From: Amanda Scholes on behalf of Planning.Responses
Sent: 20 August 2019 09:03
To: Planning Scanning
Subject: FW: BE/84/19/PL

Objection

DRAWING TITLE
SITE LAYOUT - PHASE 4c

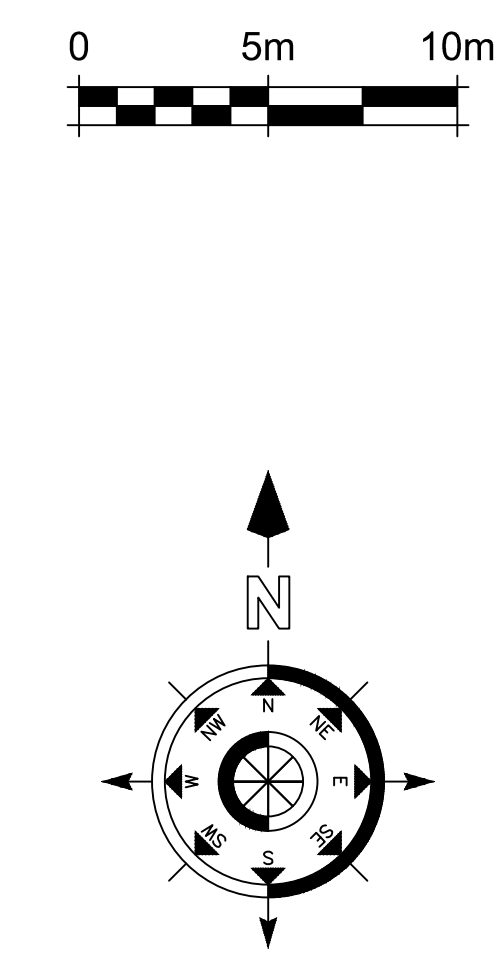
On their site plan there is very light dotting and this is the actual outline of the landscape belt.
